Your Ref	SSD-10434896
Our Ref	NCA/12/2020
Contact	Paul Sartor
Telephone	9806 5740
Email	psartor@cityofparramatta.nsw.gov.au

COUNCIL SUBMISSION

NOTICE OF EXHIBITION OF ENVIRONMENTAL IMPACT STATEMENT FOR MULTI-STOREY CARPARK AT THE CHILDREN'S HOSPITAL AT WESTMEAD (CORNER OF REDBANK ROAD AND LABYRINTH WAY, WESTMEAD)

MSCP ENTRY RAMP LAYOUT DETAILS

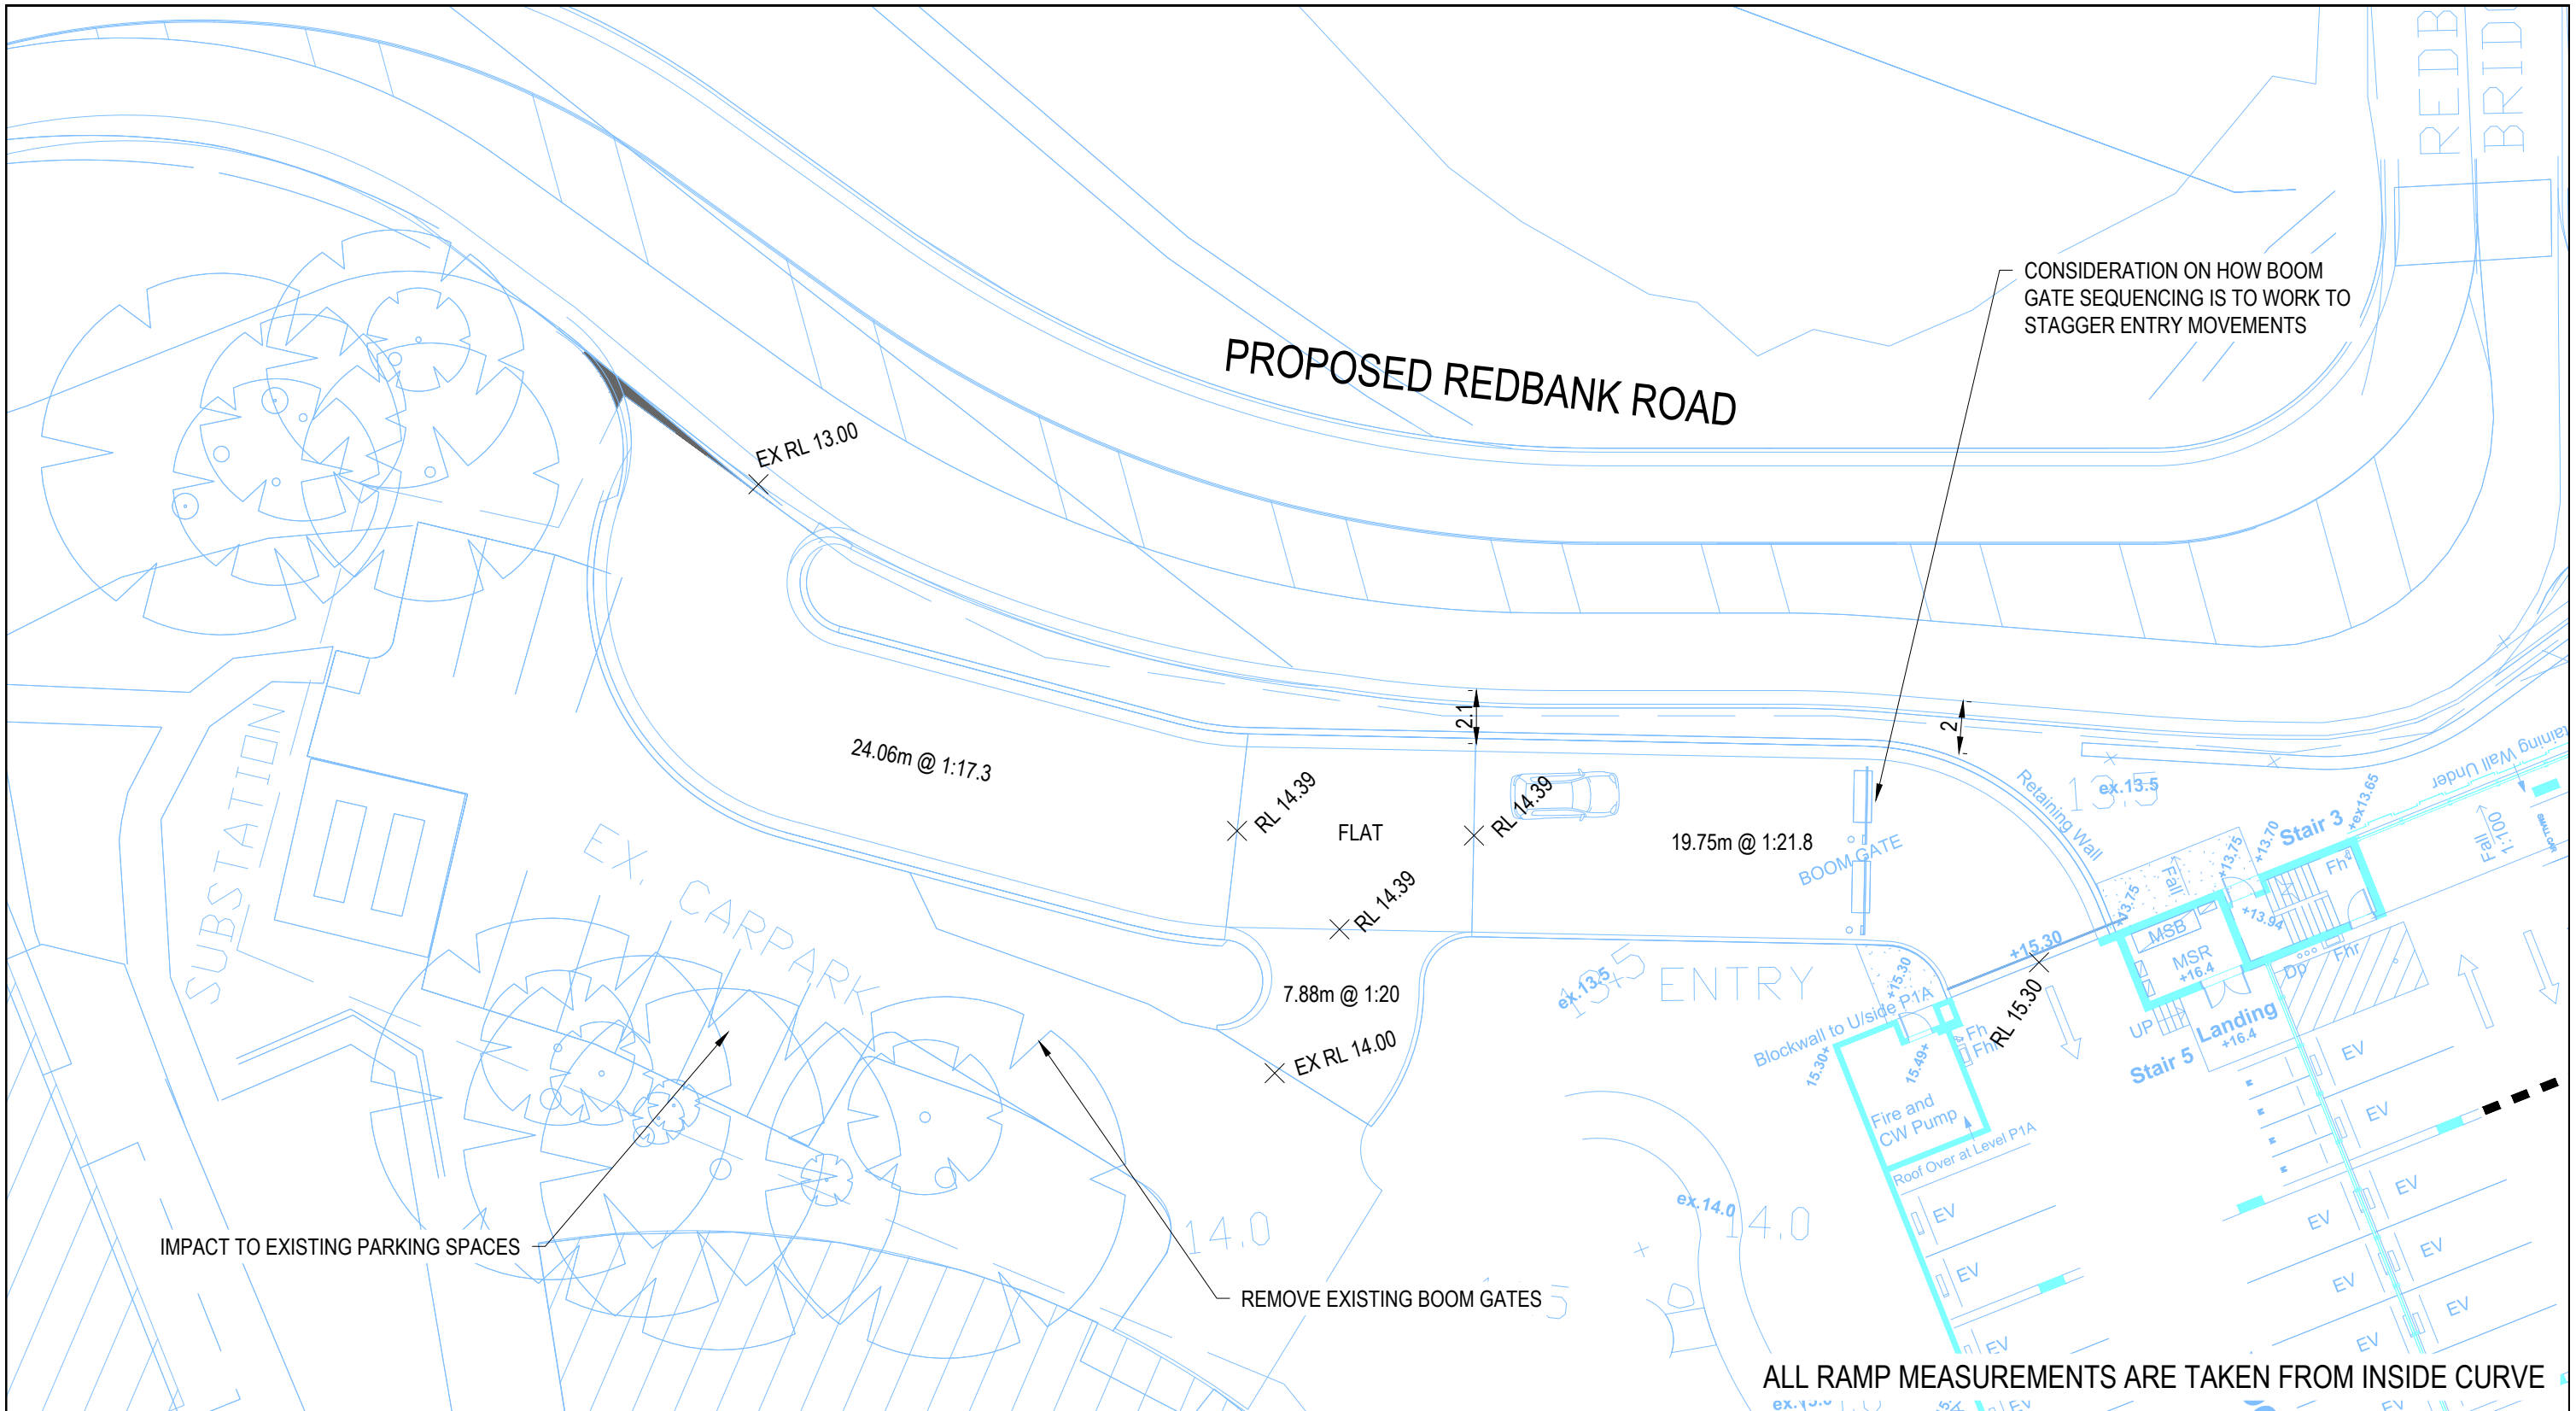
- Entry and exit ramp gradients were not provided and therefore cannot be peer reviewed. Note that ramp gradients will have to comply with Clauses 2.5 and 2.6 of AS2890.1-2004.

PS118400 SK131
AUSTROADS 6.4m TRUCK
SITE INGRESS/EGRESS MANOEUVRE
C.W. 06.04.2021

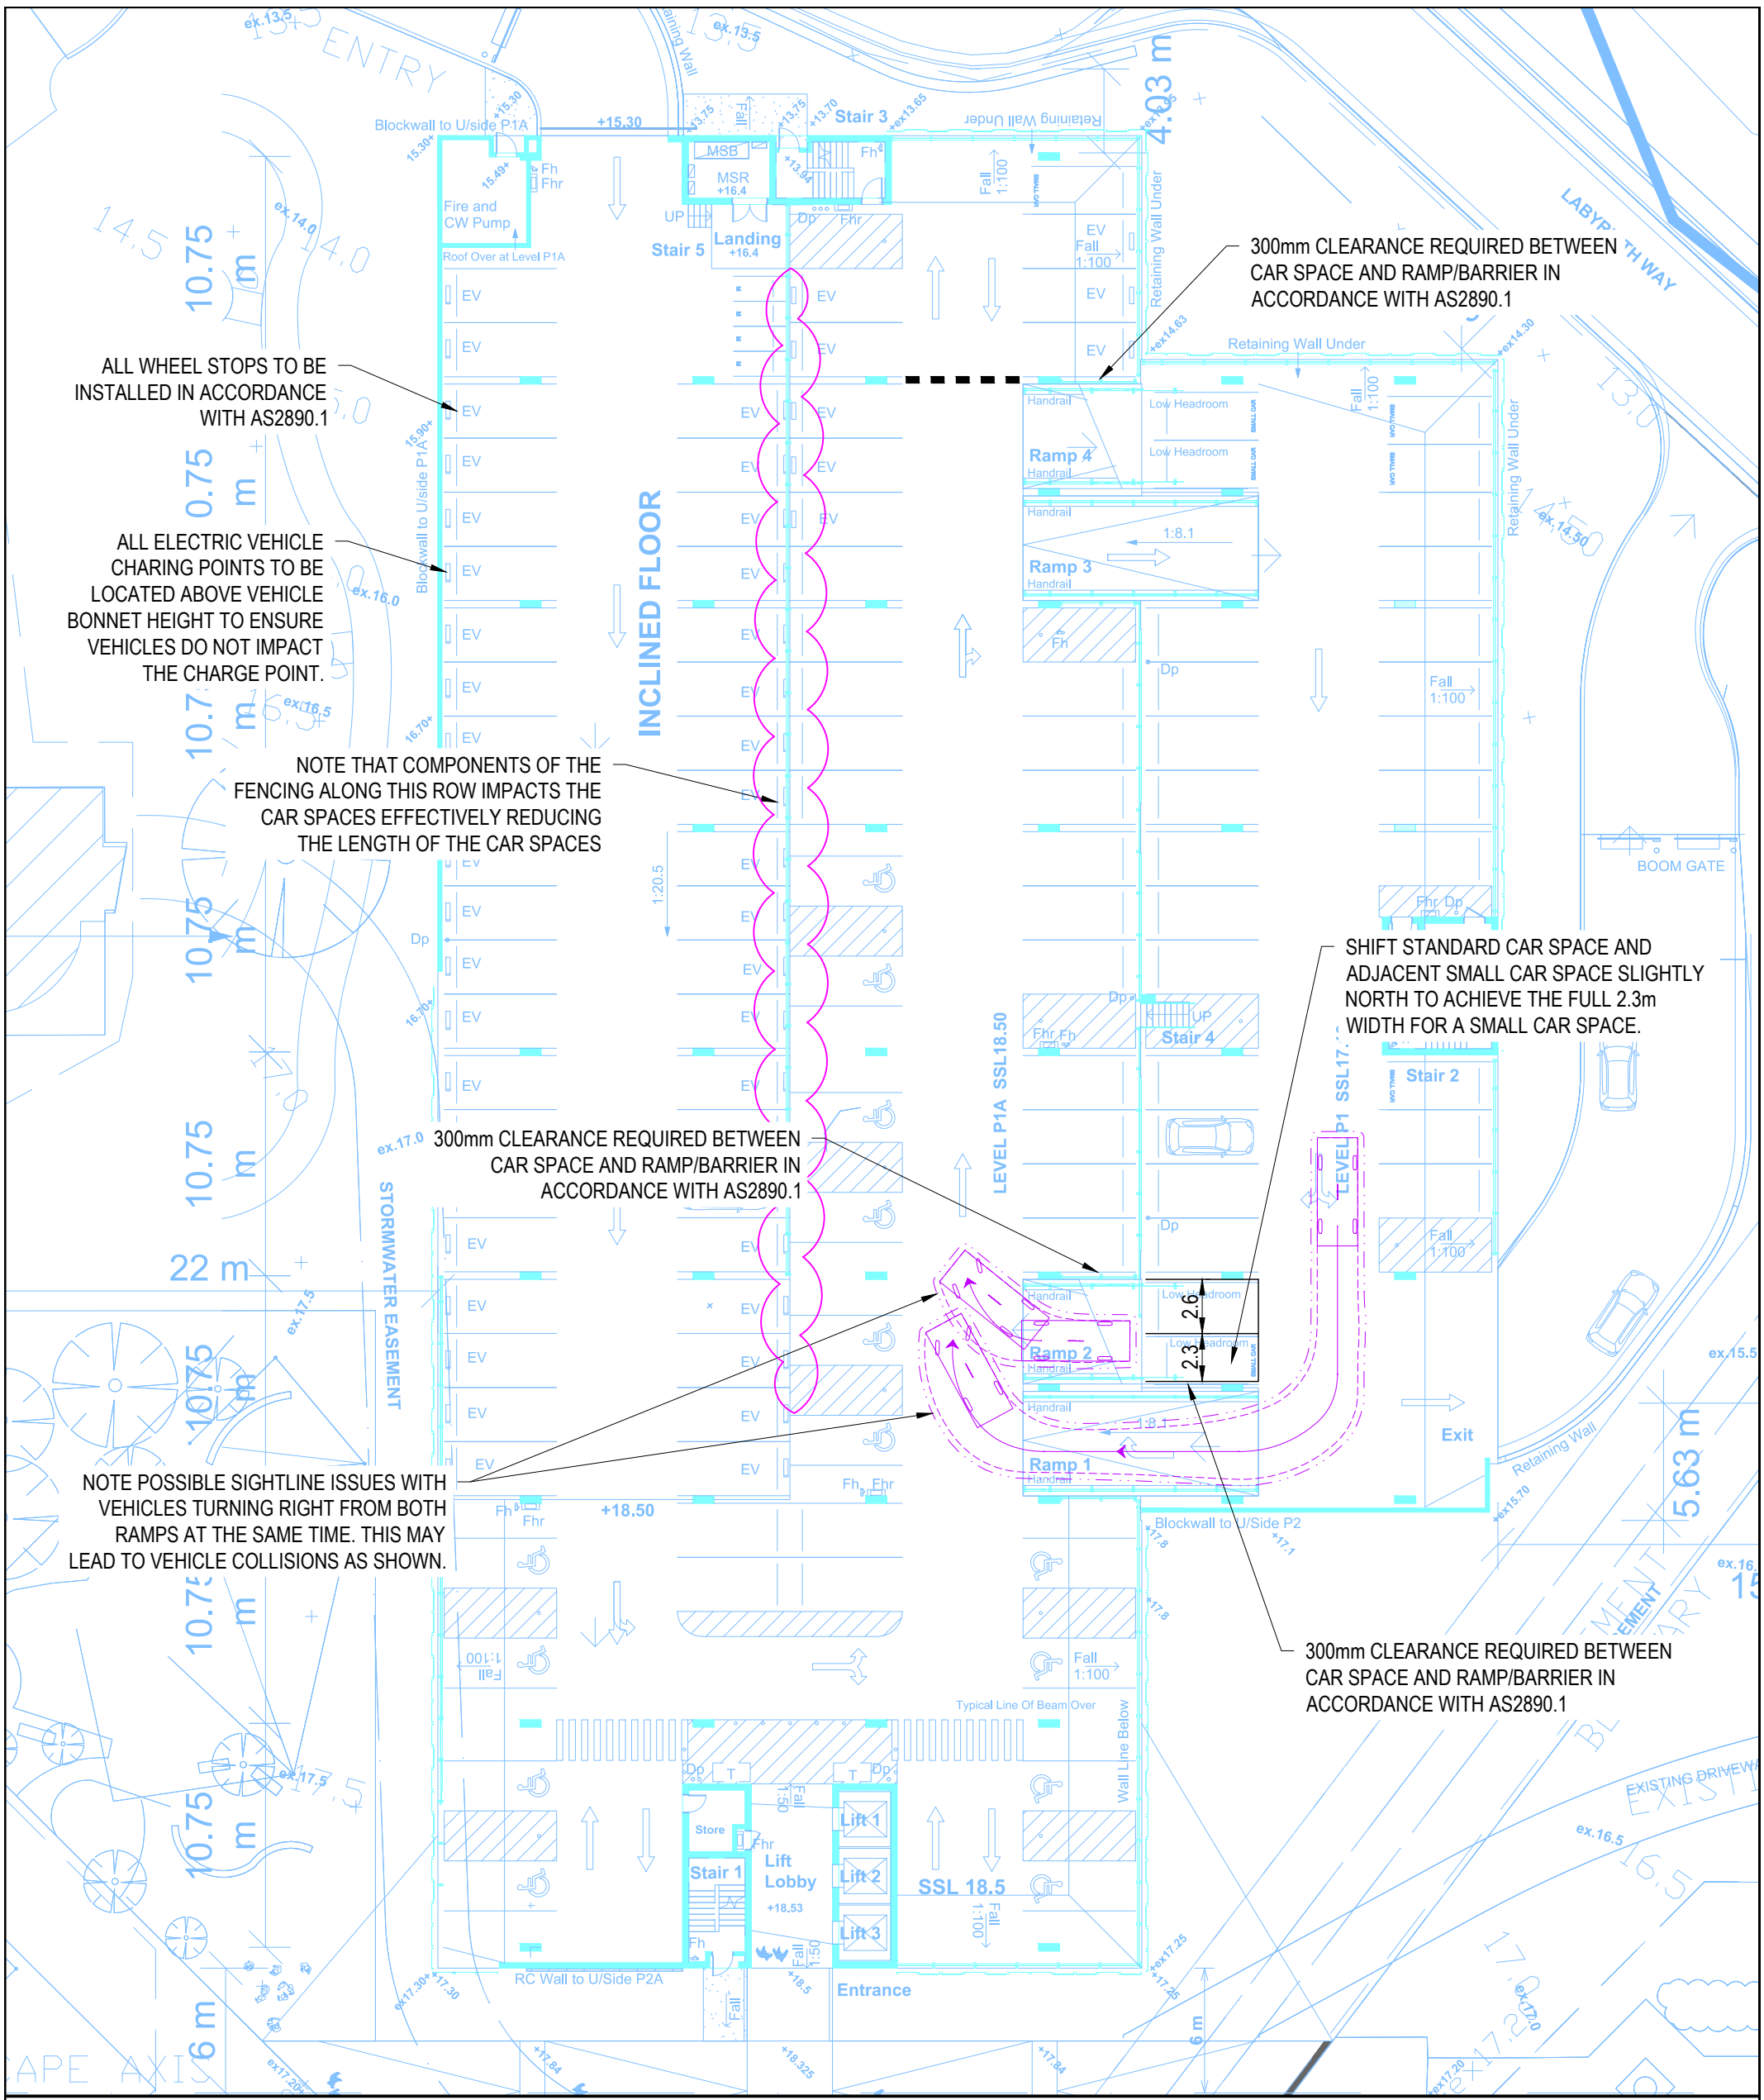
- The car park design including aisle widths, column locations, swept paths and sight lines are to comply with AS2890.1
- Swept path for a 6.4m service truck indicates that several spaces would need to be unoccupied in order to park/exit the designated car space. Additionally, the truck is required to park in two car spaces which means the adjacent car space will also need to be kept unoccupied. It is unclear how these spaces will be managed and kept unoccupied to allow the service truck to access/exit the spot.

PROPOSED PARKING PROVISION FOR LEVEL P1 & P1A:
- 112 CAR SPACES
- 4 MOTORCYCLE SPACES

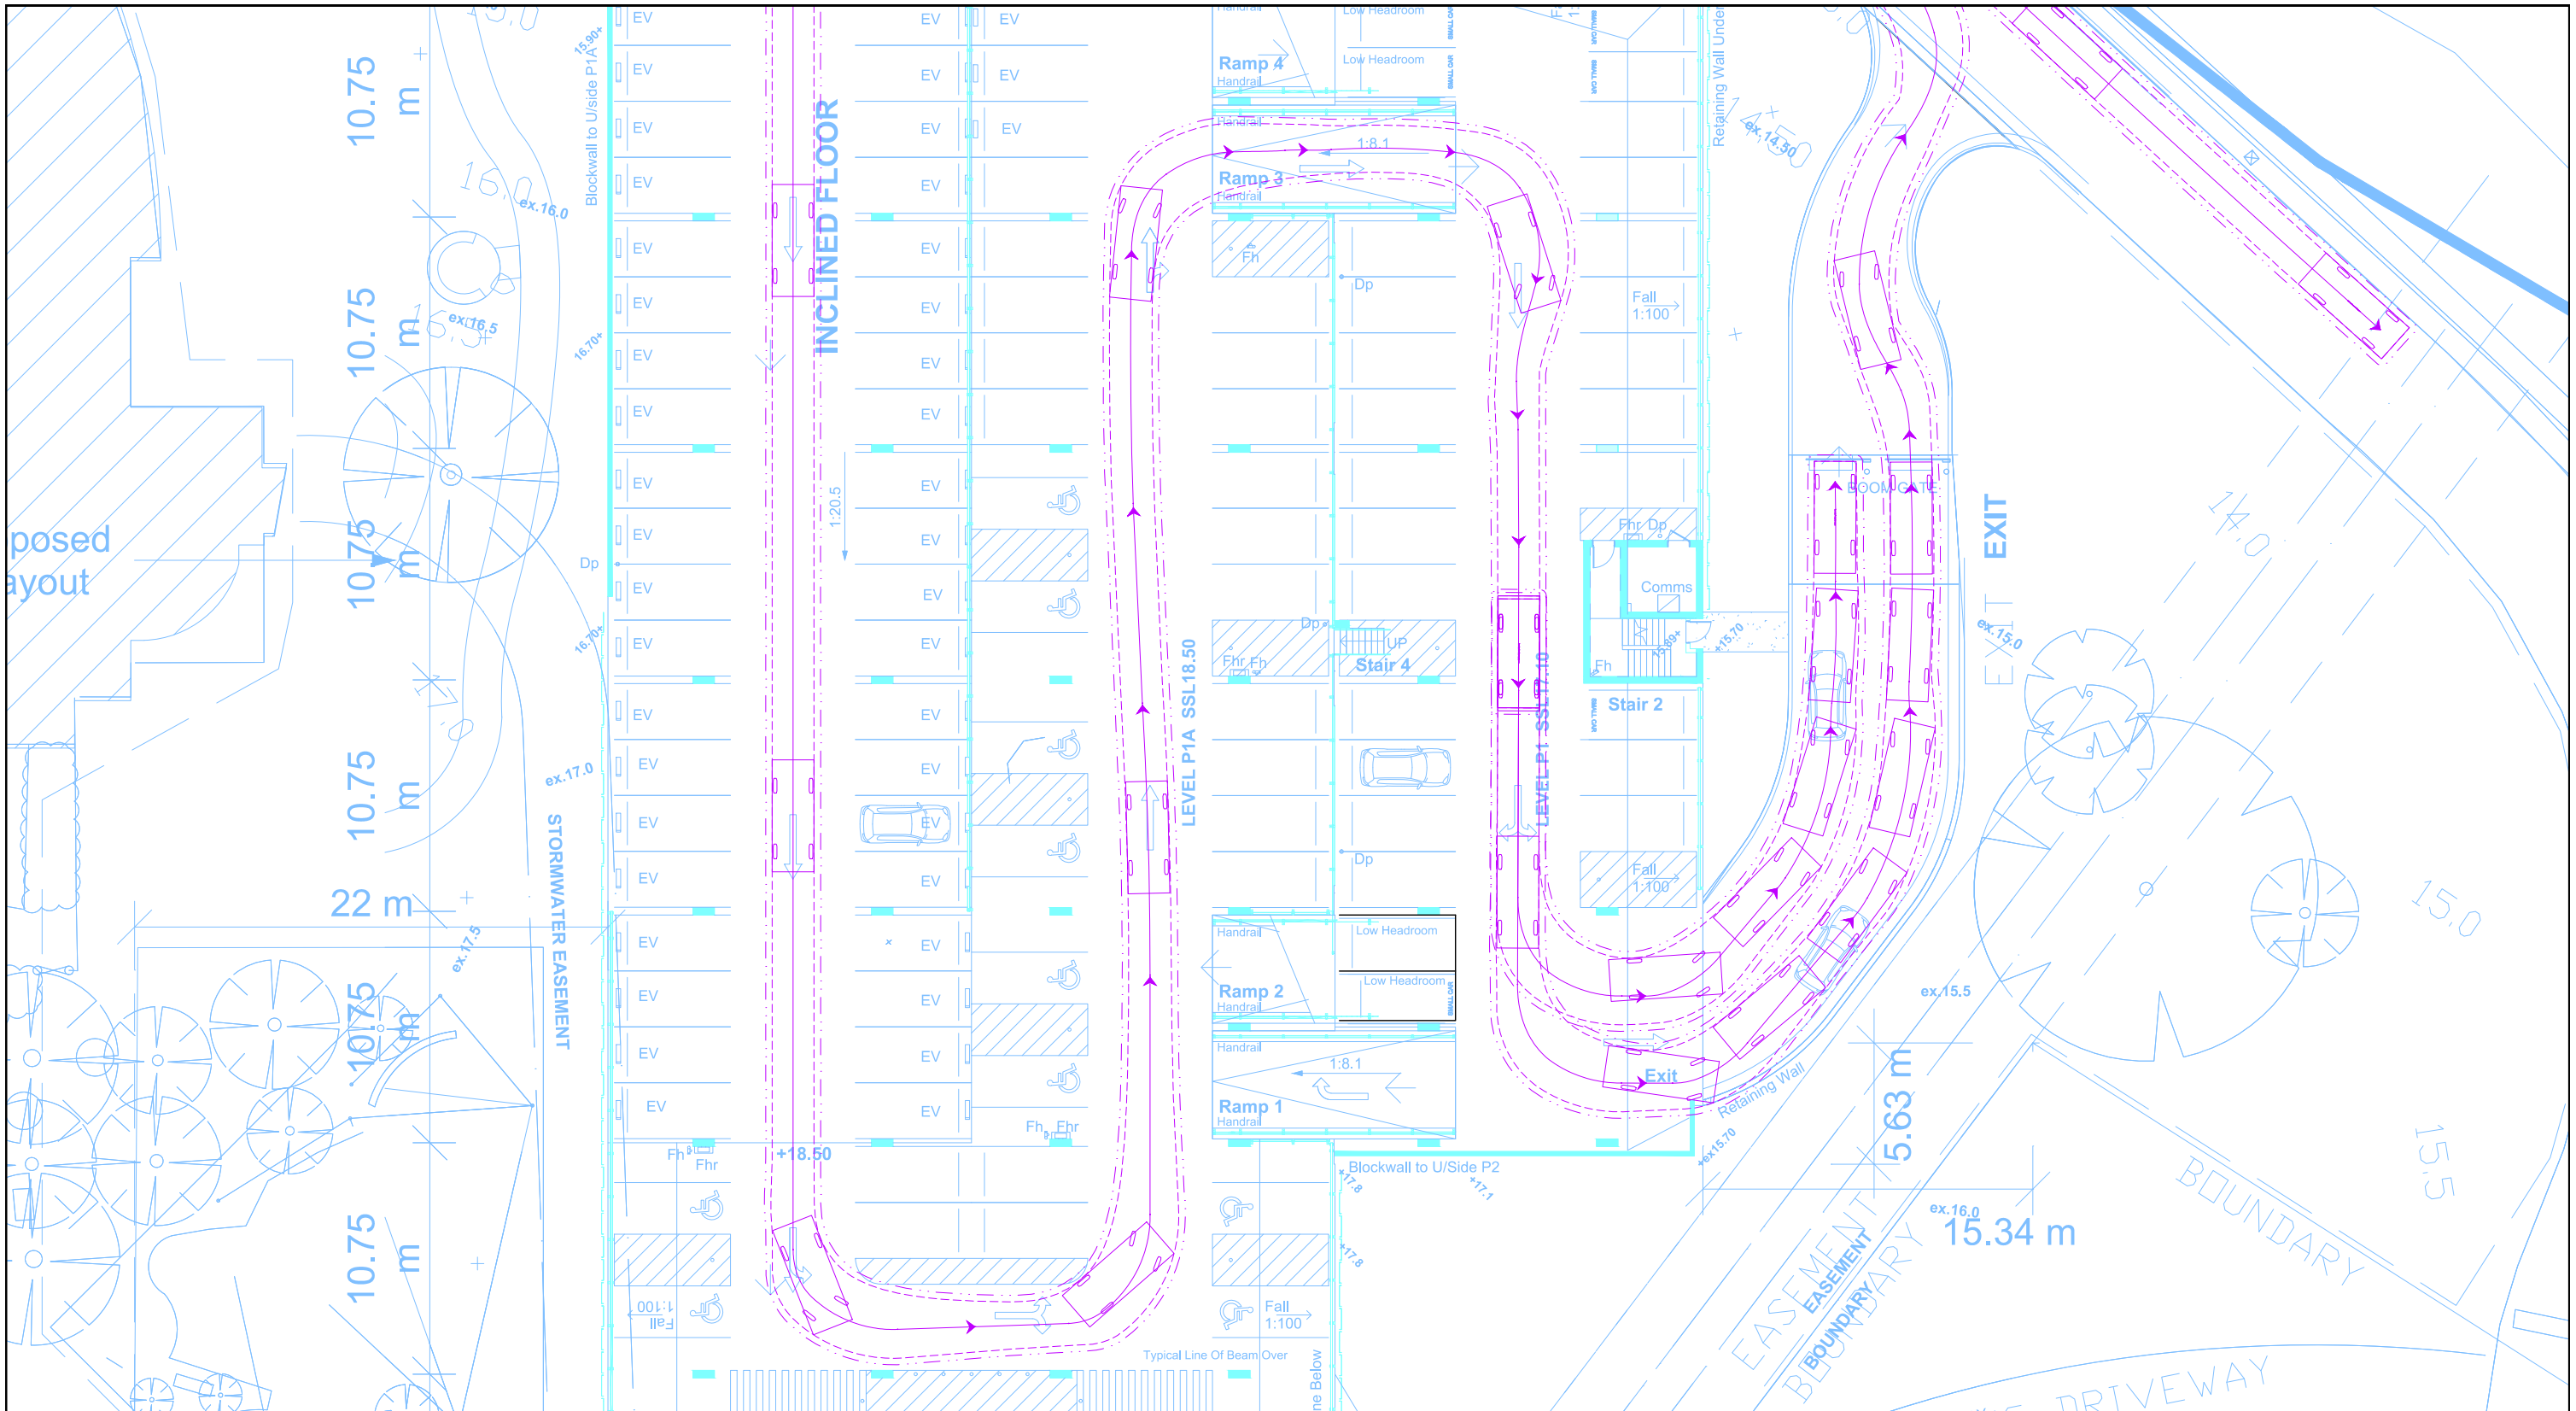
- The submitted architectural plans show only four motorcycle spaces accommodated in the car park although 21 motorcycle spaces have been identified to be required in the TA report. The car park design should be amended to accommodate 21 motorcycle parking spaces.
